Please find below Council's submission on this application:

Vehicle Crossing, Driveway & Parking

POST-DEVELOPMENT CATCHMENT AREA  
NTS

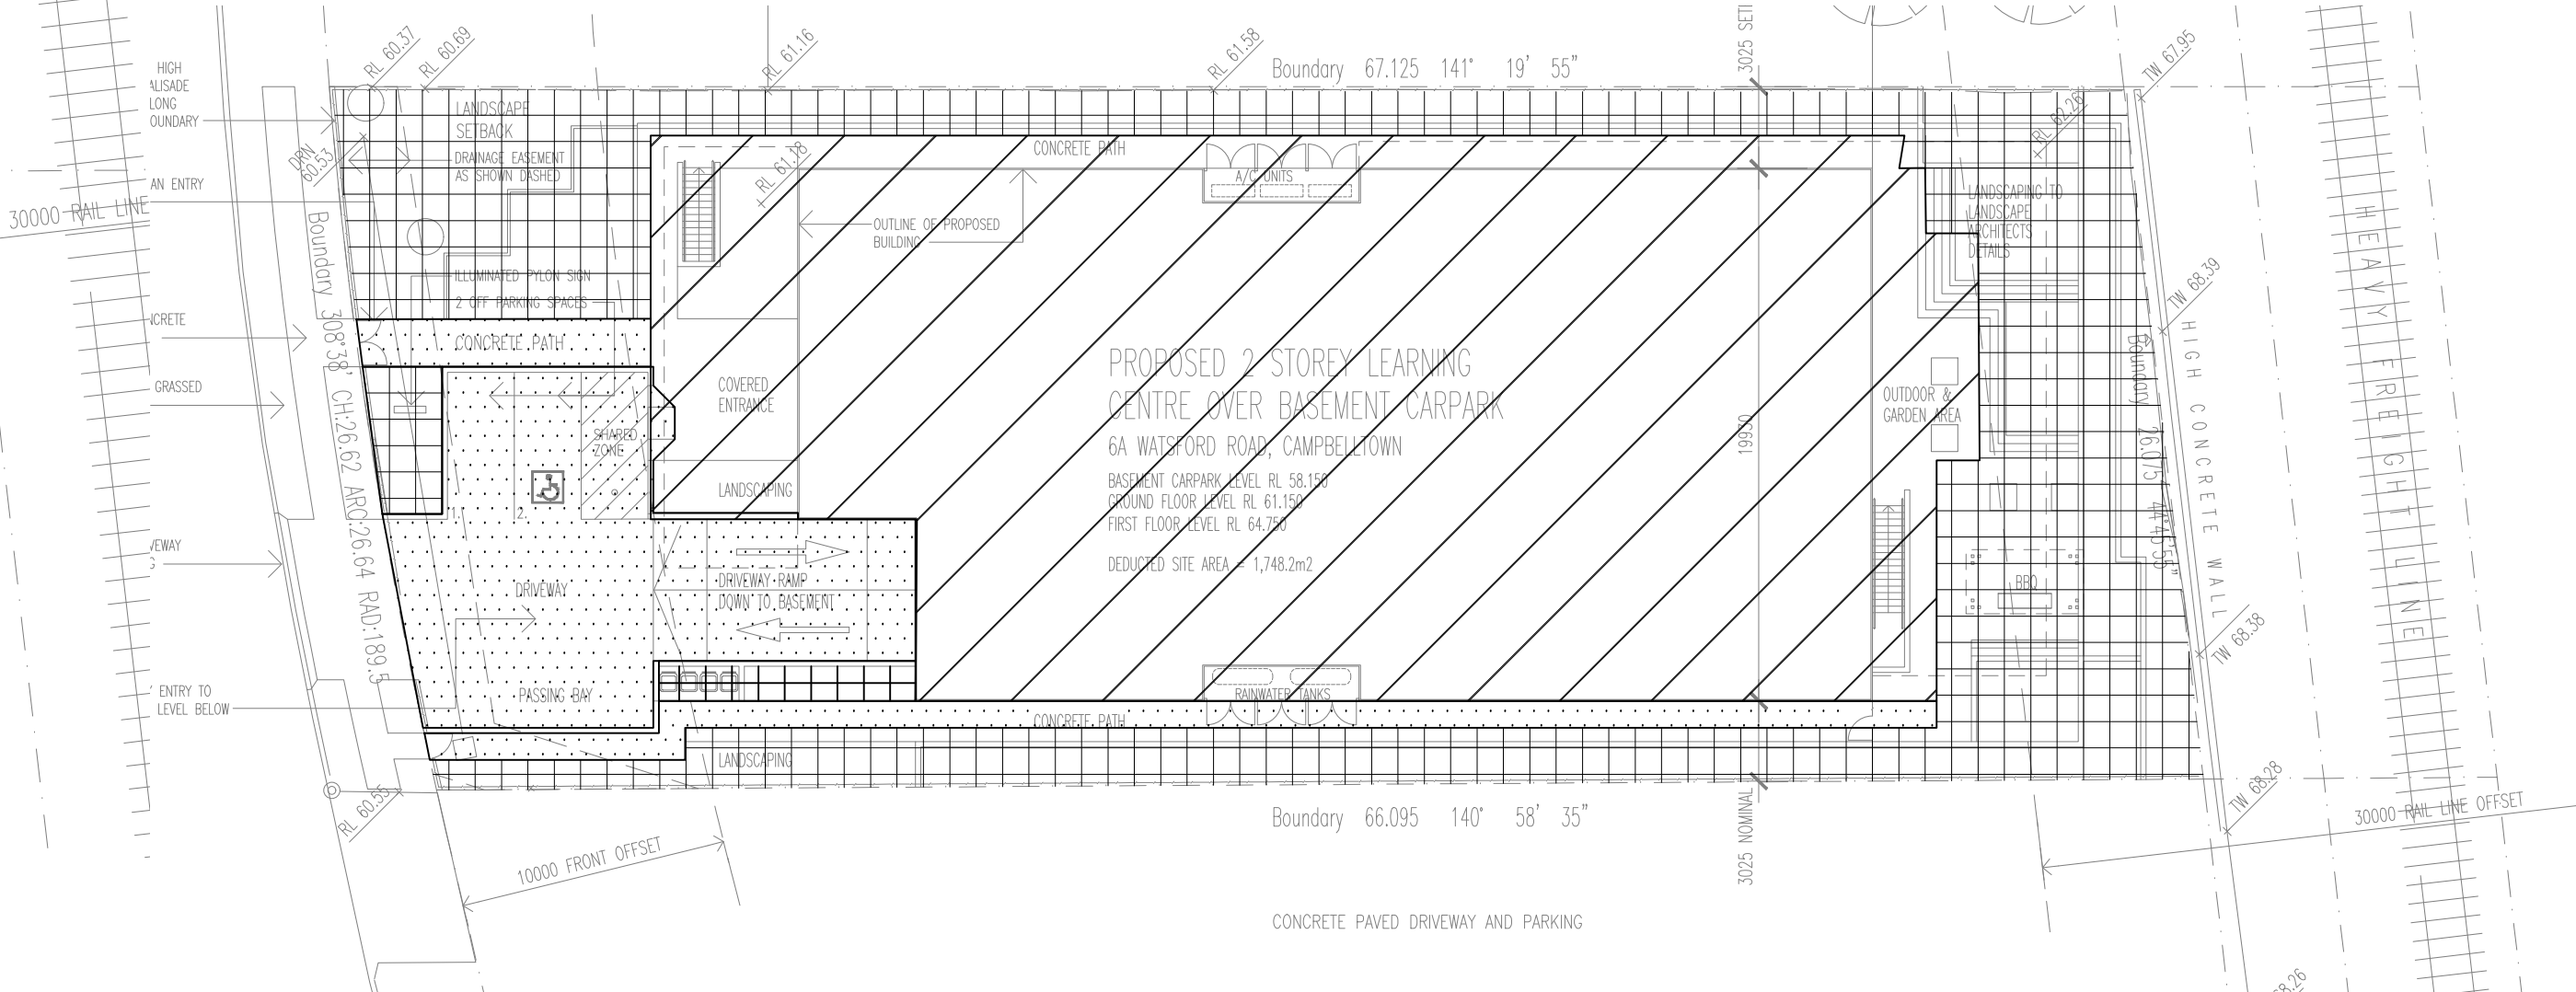
1. No stormwater calculations have been provided. Calculations shall be provided as per Council's Engineering design guide and may require redesign of the stormwater configuration.

2. Stormwater shall comply with Council's Engineering Design guide for developments.
3. The applicant shall demonstrate limiting post-development flow to pre-development flow, and this may require provision of an On-site detention system.

4. The pipeline in the road reserve shall be reinforced concrete minimum (375mm diameter class 3 minimum).
5. The proposed piped connection from the boundary to the existing kerb inlet pit will require adjustment / relocation of services (Sydney Water, Telecommunication, Electricity). This shall be undertaken at the applicant's cost and to the satisfaction of Council and relevant utility authority.

8. It is noted that there is a drainage easement adjacent at the front property boundary however it is unclear why. It may be related to the sub-division of the parent lot into lots 6 & 6A.

LOWER GROUND FLOOR PLAN

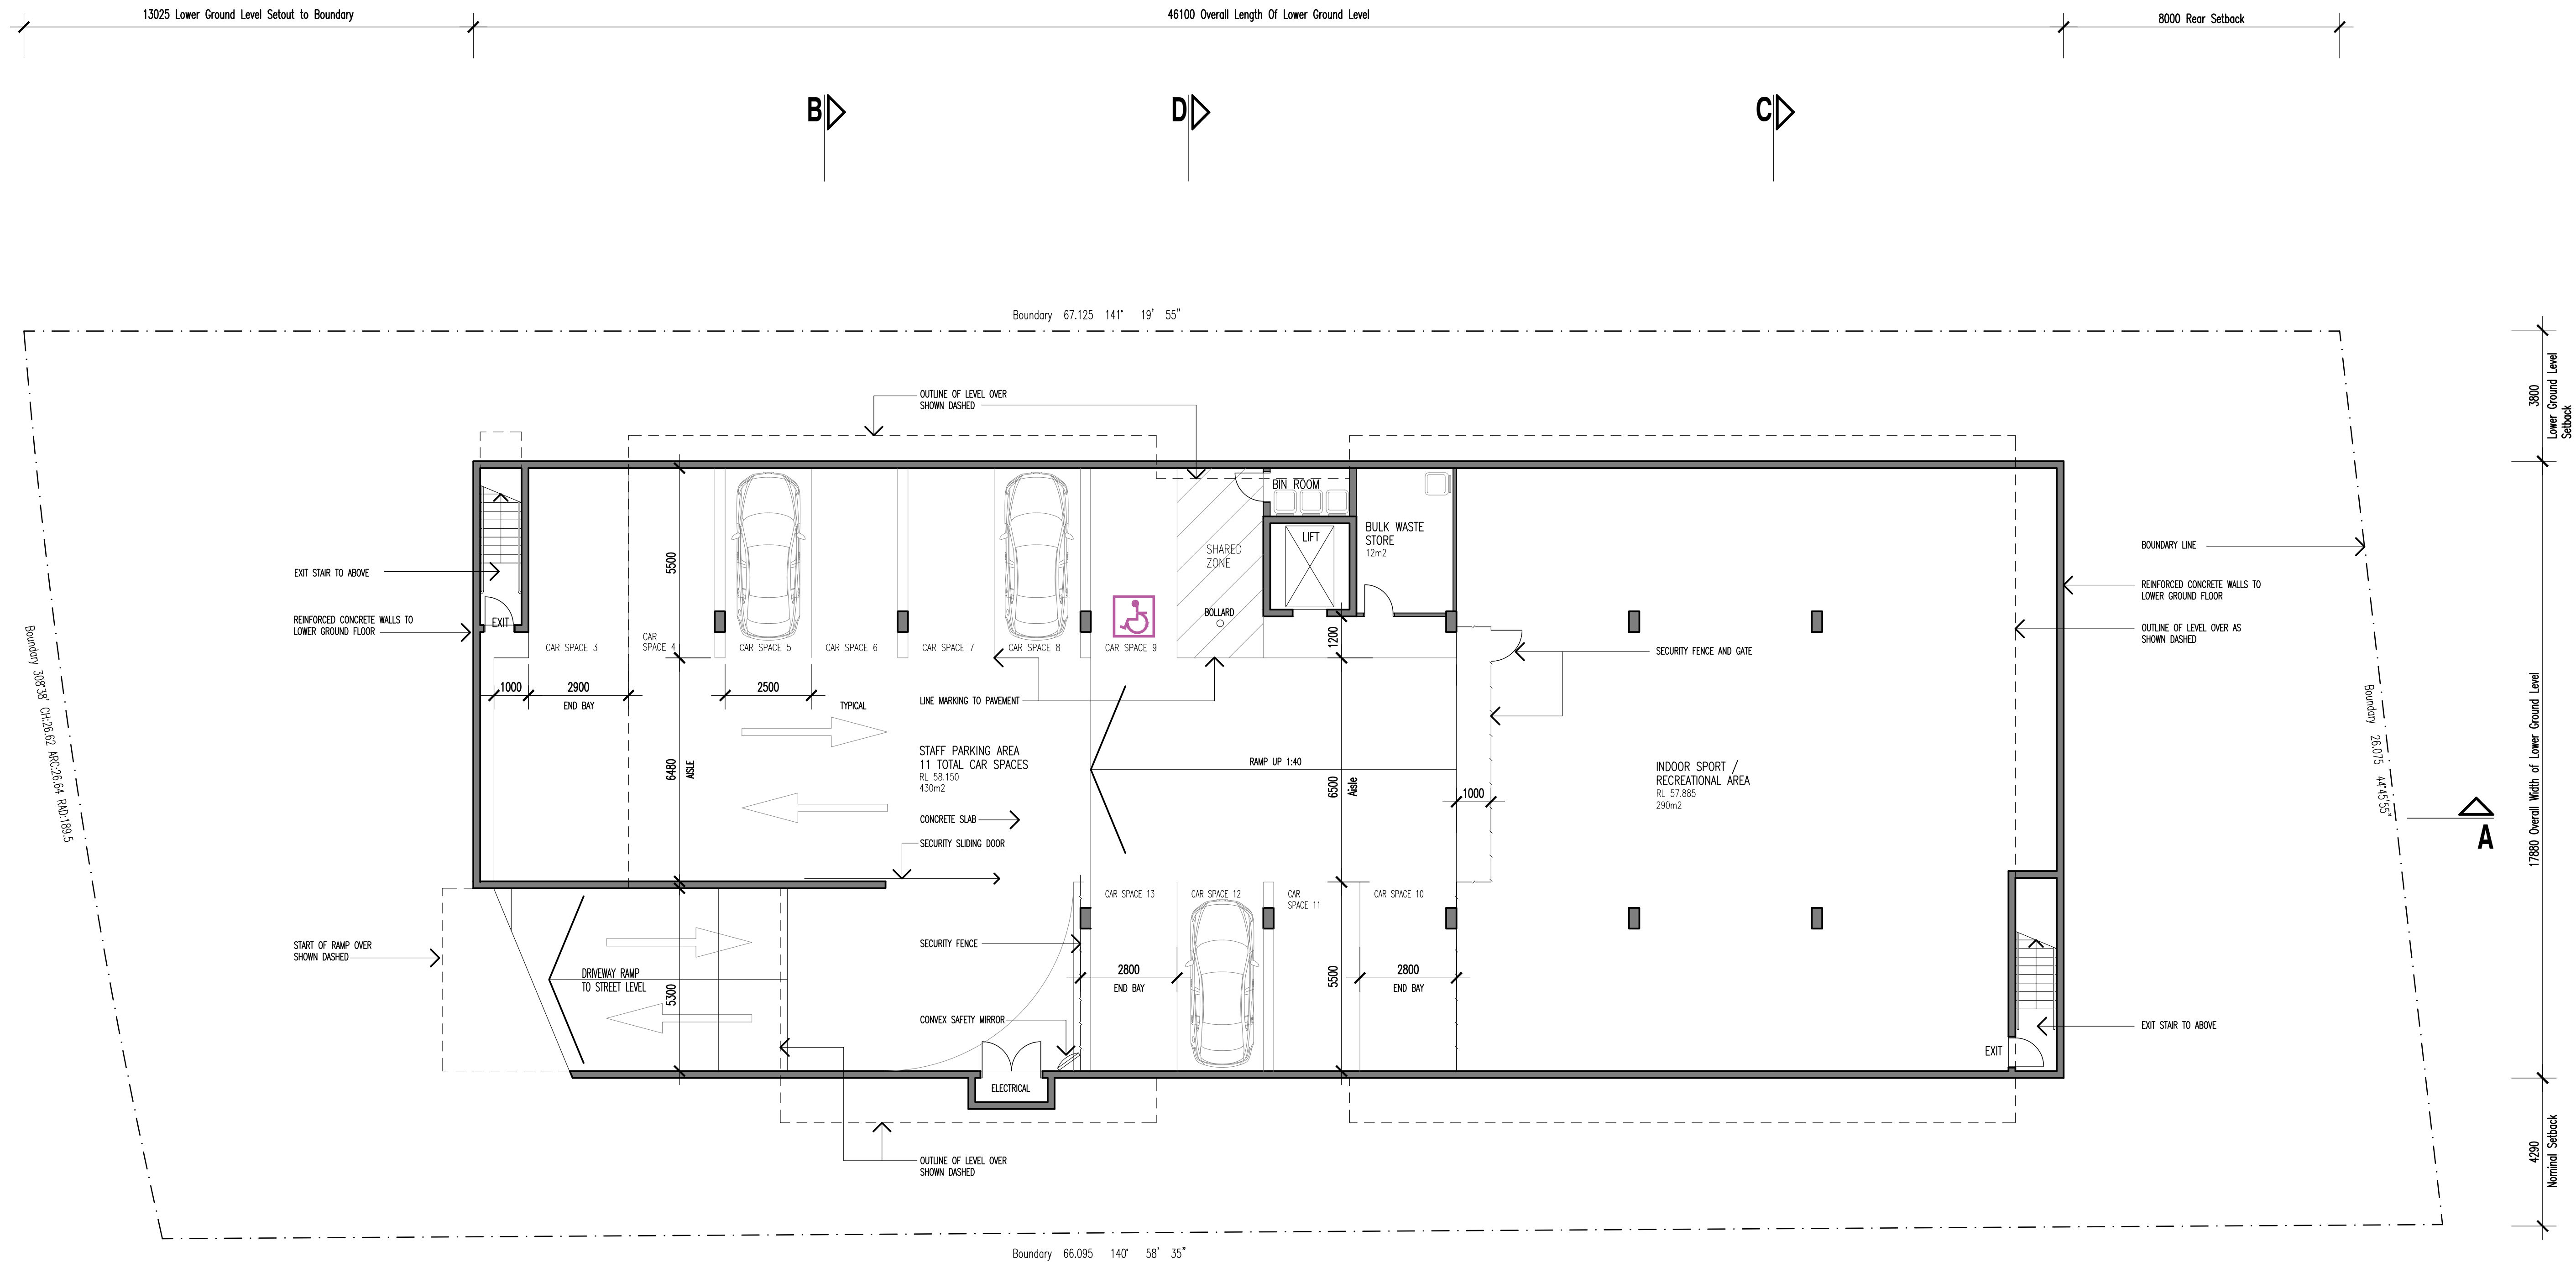
1. The minimum width of the driveway shall be 5.5m wide clear of walls, edges from property boundary to Lower Ground floor facilitate the two-way movement as per AS2890.1 (Clause 3.2.2)
2. Parking spaces and aisle widths are satisfactory.
3. Driveway gradients - No driveway profile has been provided. The floor levels provided, minimum clear height on ramp and lower ground floor, driveway grades and transitions cannot be assessed against AS2890.1 without a driveway profile.
4. The vehicle crossing and corresponding layback in the road reserve shall comply with Council standard drawing SD-R10 Sheets 1 & 2.
5. The Waste management plan doesn't clearly specify the waste collection strategy,
6. An MRV vehicle is nominated for waste collection - swept paths for an MRV servicing the site shall be provided. Paths and driveway grades for an MRV shall comply with AS2890.2.

6. The applicant shall provide a dual pump system for the basement in line with Council's Engineering Design Guide for Development.
7. The proposed pump-out system in the basement is to have a backflow prevention device installed.
